Our Ref: AL/35/21/DOC

Approval of details reserved by condition imposed on AL/34/20/PL relating to condition 5-site plan showing details of hard landscaping.

Norton Farm House Norton Lane Norton PO20 3NH

Arun District Council have decided to **REFUSE details reserved by condition for the following reasons:**

DRAWING TITLE
EXTERNAL WORKS

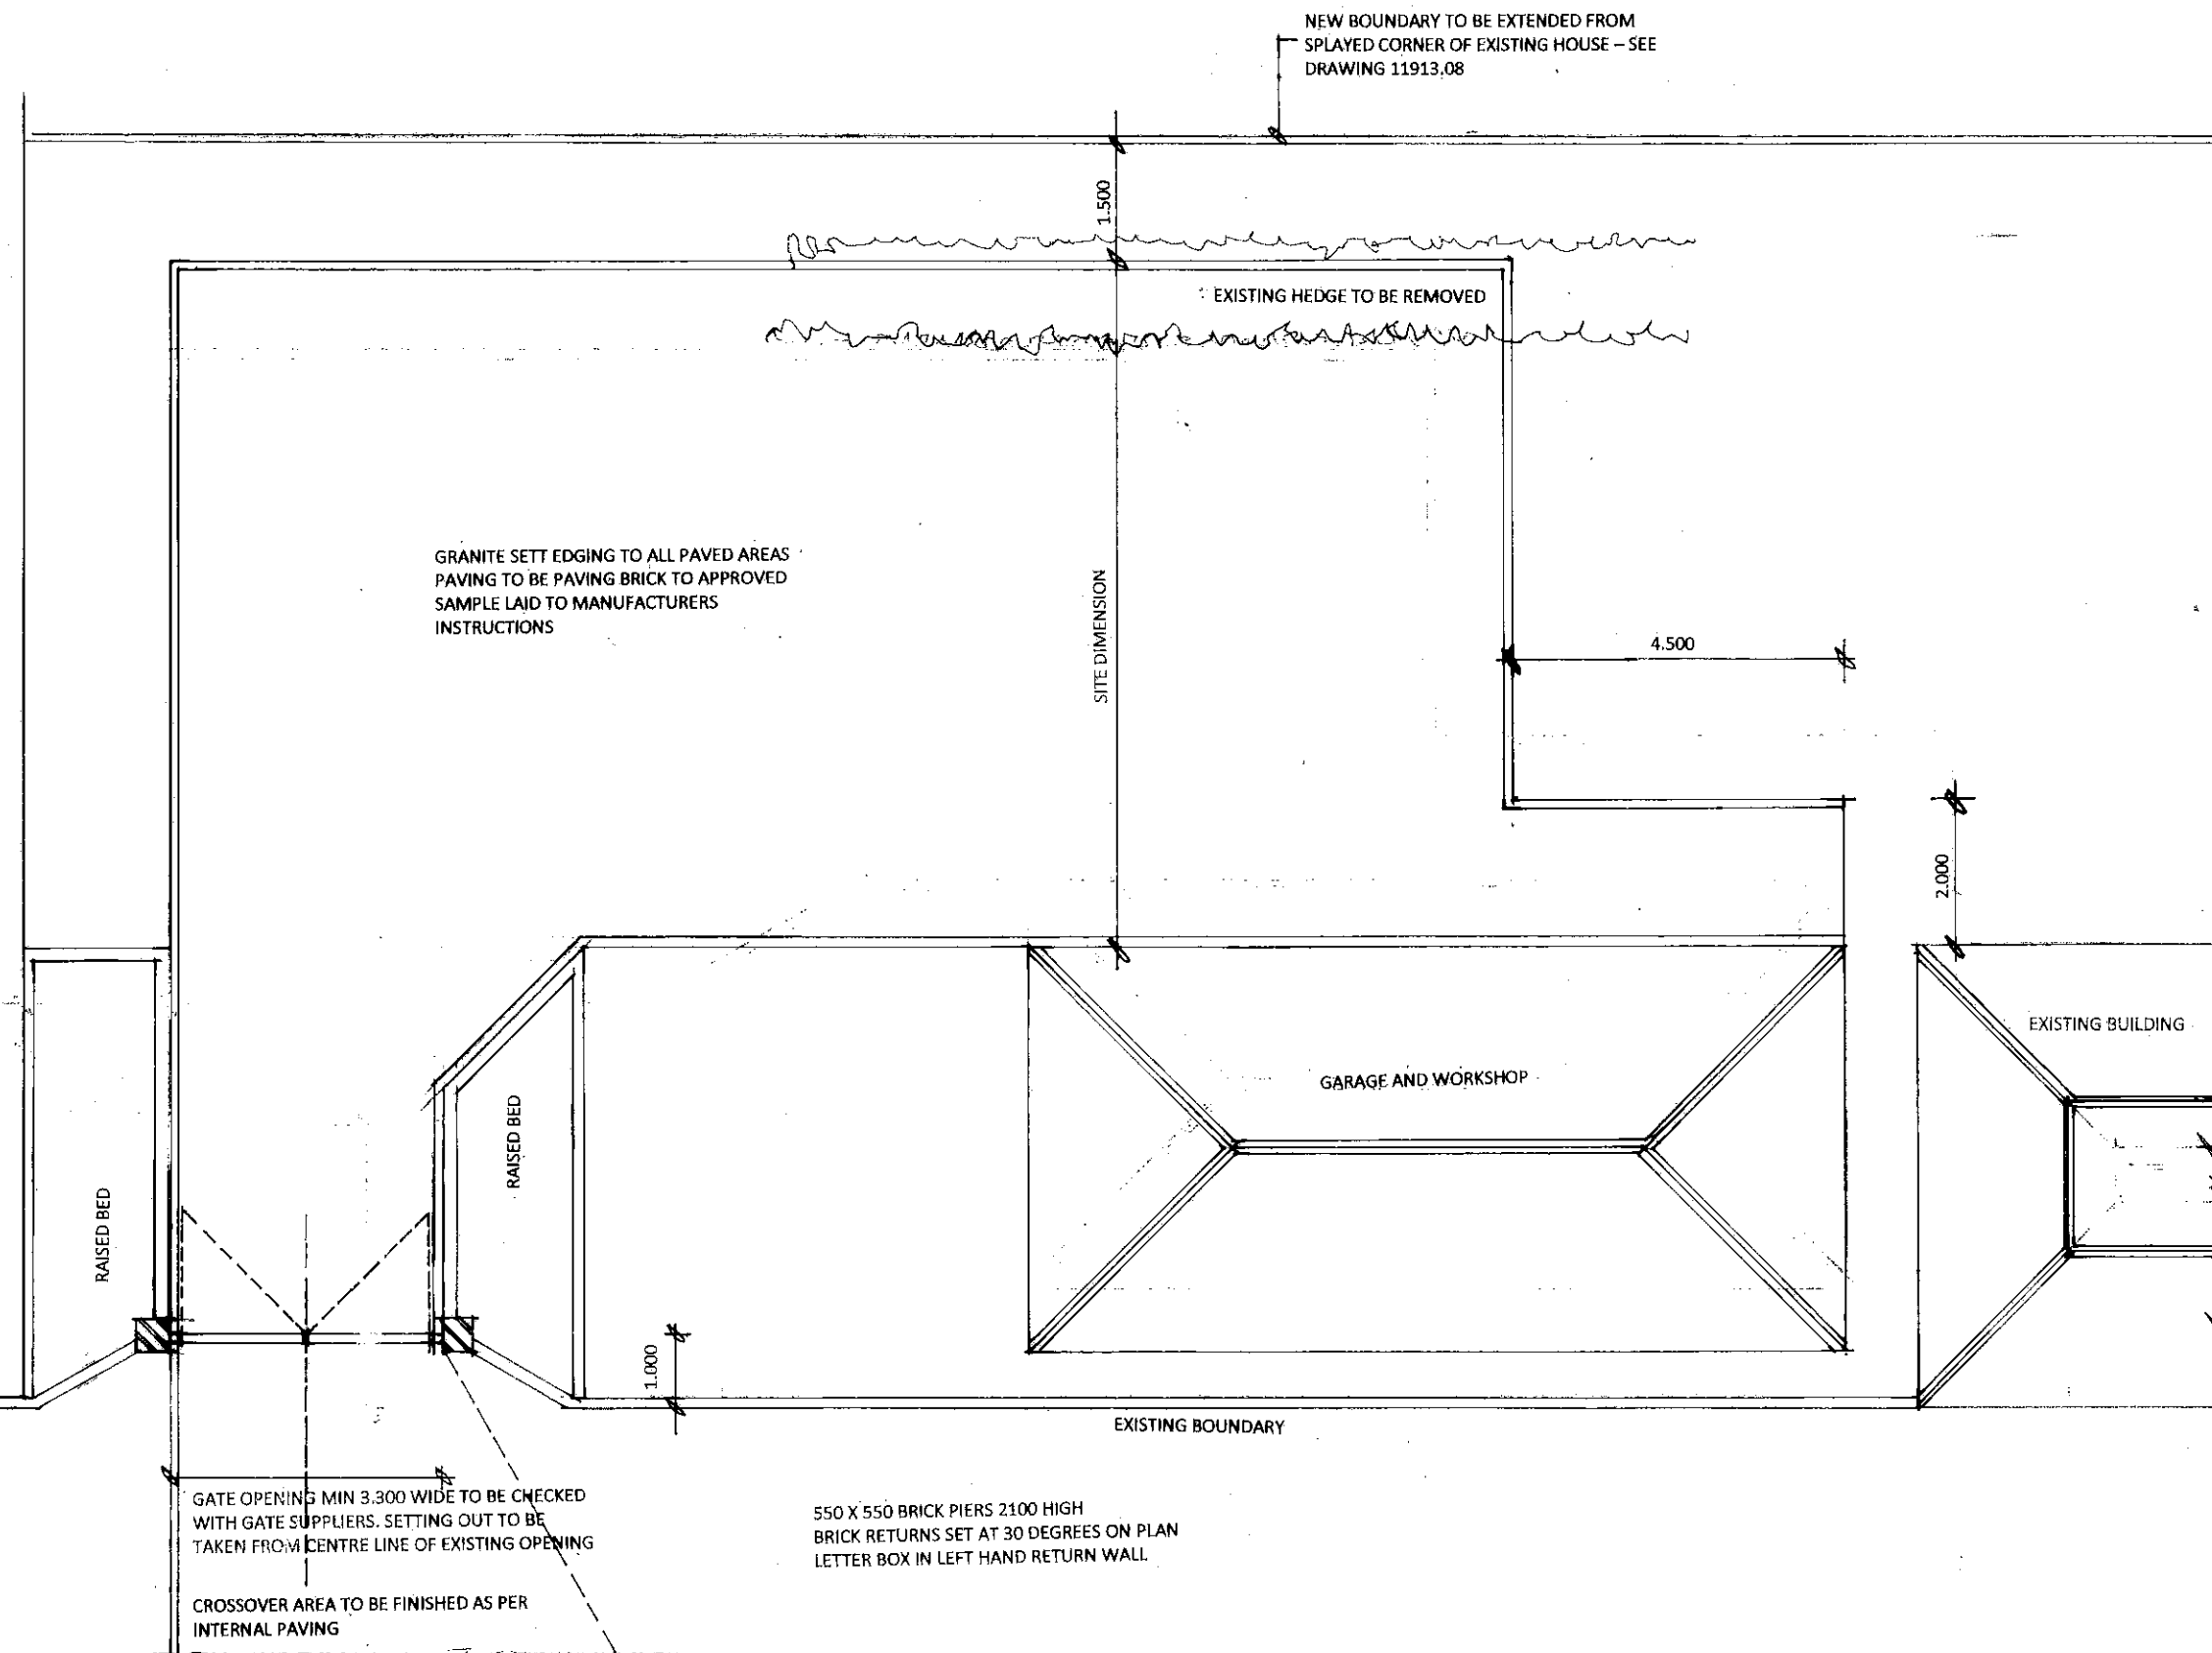
The discharge of condition (5) related to details of the hardstanding is refused due to harm to the character and appearance of the Conservation Area and the setting of the nearby Listed Building.

Objection received from Council's Conservation Officer. Due to the large expanse of paving and the paving being a standard material, which results in a more suburban character, without appropriate boundary treatments/screening, the paving would be visible from both the Conservation Area and within the setting of the Listed Farmhouse and could be harmful. This would be contrary to the NPPF, which states any harm or loss of significance to heritage assets requires clear and convincing justification, and where 'less than substantial' harm would be caused this should be weighed against the public benefits. In this case, it is considered the harm would not be outweighed by any public benefits. The proposals would also be contrary to Arun Local Plan policies HER SP1, HER DM1 and

HER DM3 which seek to protect Listed Buildings and Conservation Areas from harm. The proposals would also be contrary to the Planning (Listed Buildings and Conservation Areas) Act 1990 which seeks the preservation of the significance of Listed Buildings and their setting and the character or appearance of Conservation Areas.

In order for the LPA to be in a position to approve the discharge of this condition, an application for the discharge of condition 6 (boundary treatment details) must be submitted and approved either prior or at the same time as an application for the discharge of condition 5 (hardstanding details). This would ensure appropriate screening is in place to avoid any harm from the hardstanding to the character and appearance of the Conservation Area and the setting of the Listed Building.
